From: Amanda Scholes on behalf of Planning.Responses
Sent: 10 March 2017 09:33
To: Planning Scanning
Subject: FW: Small Yard North Bersted St. Comments on the Holy Cross Church objections.
Importance: High

Letter of support from the applicant – BE/180/16/PL

We note from the planning web-site, the objections raised by Holy Cross Church, to which we respond as follows; -

SECTION SCALE 1:100

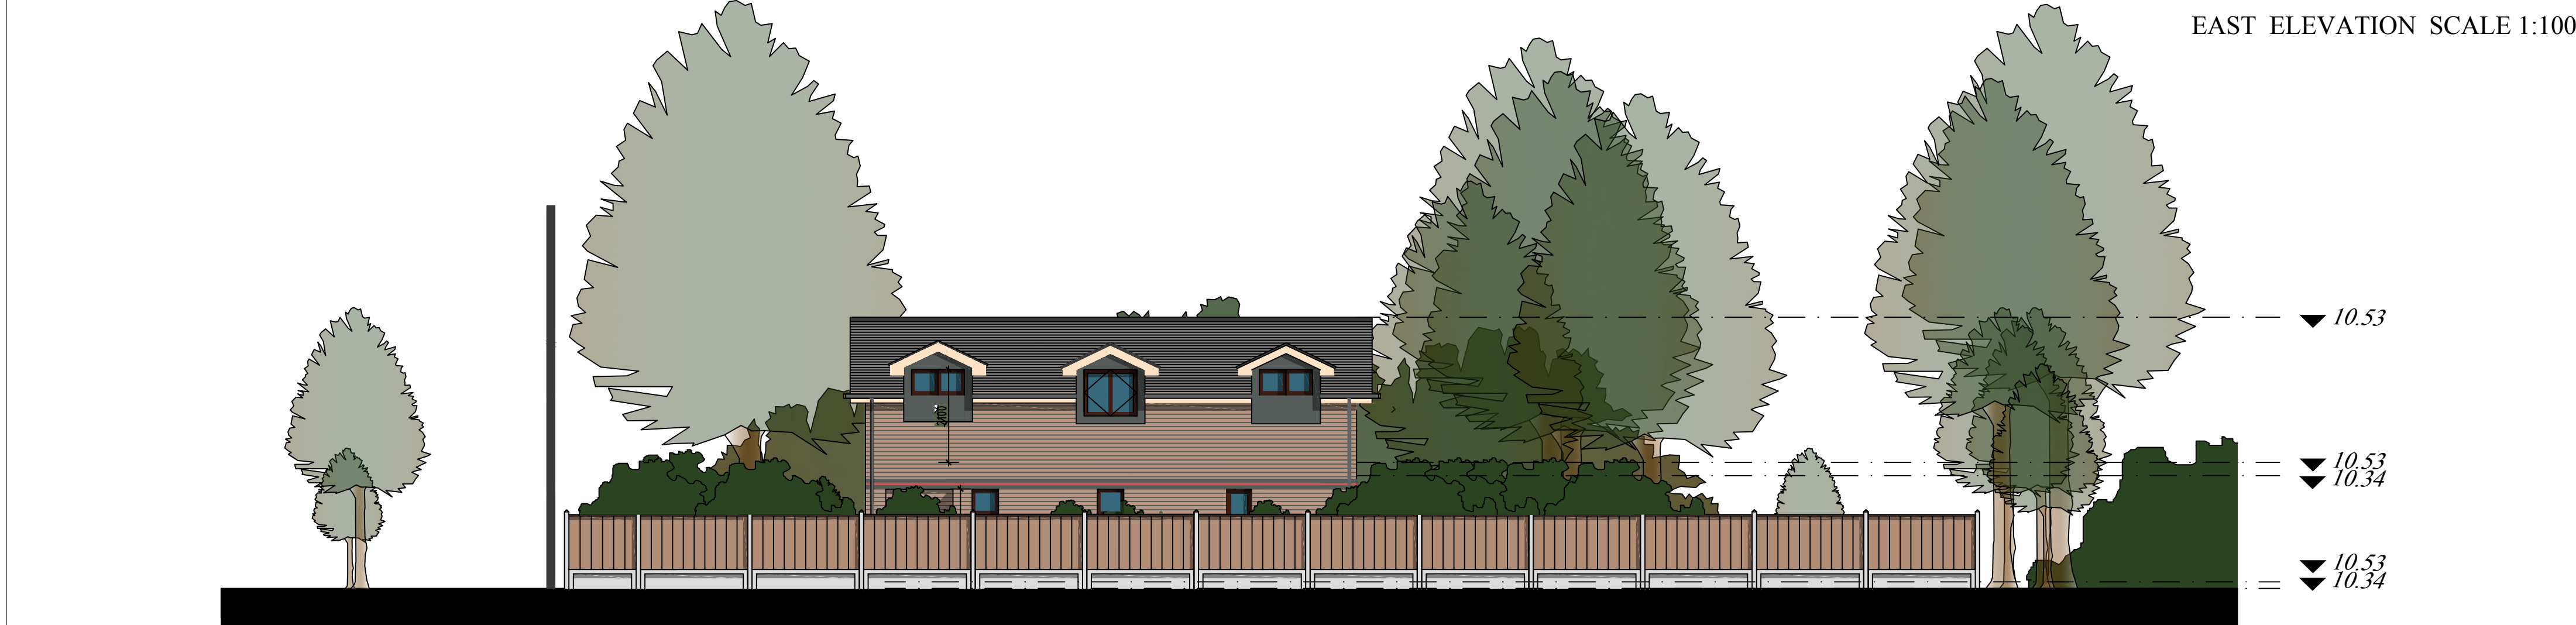
- The light to the church hall is already severely cut off by the churches own substantial hedgerow. The proposed development sections show that the proposed building is some 7 meters from the Church Hall and is no higher than that building so any additional shading beyond that from the existing hedge will be insignificant.

Project
NORTH BERSTED STREET
BOGNOR REGIS
Drawing
Site Lines & Parking

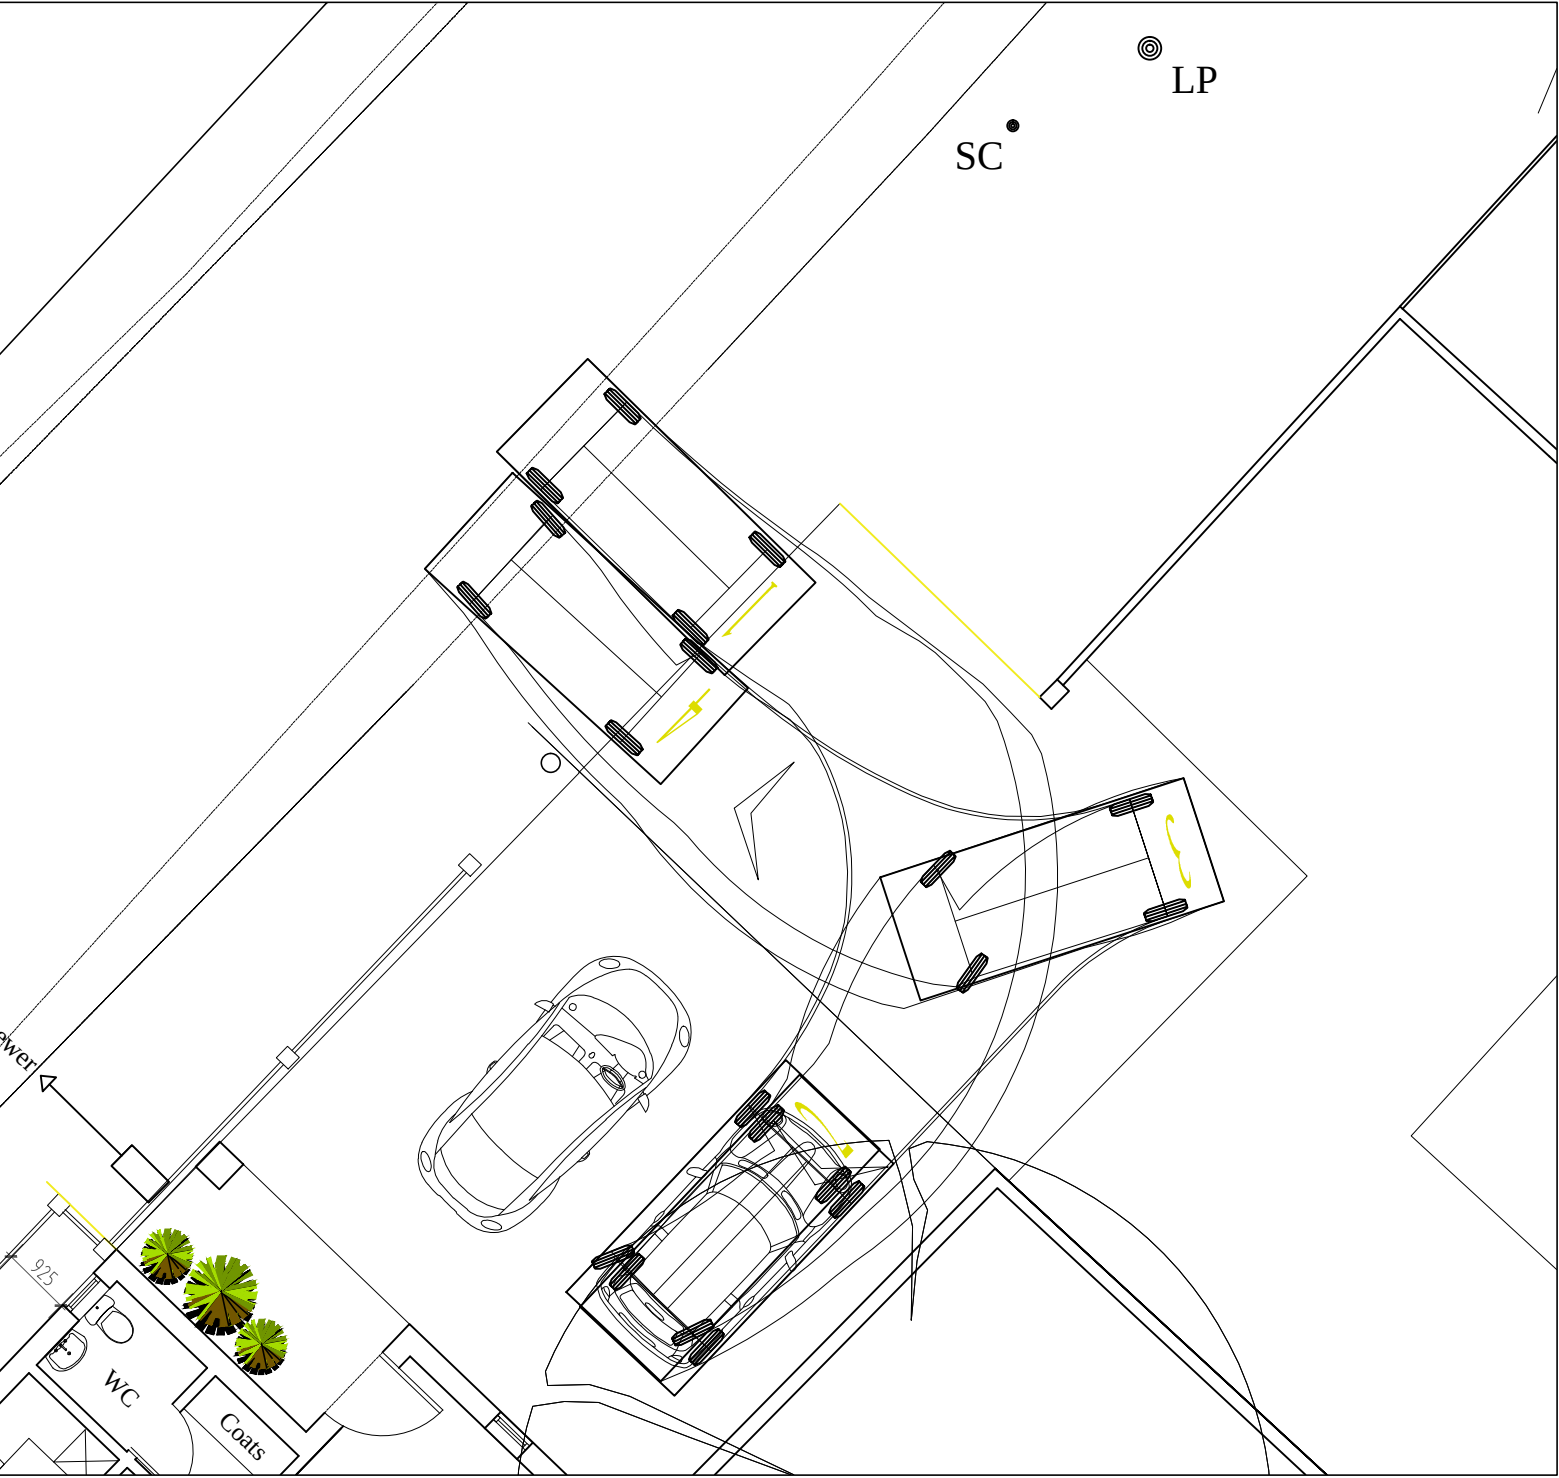
- We have addressed the concerns of WSCC Highways & await their response. We note that our proposal does not affect the visibility splay to the Church entrance in any way.
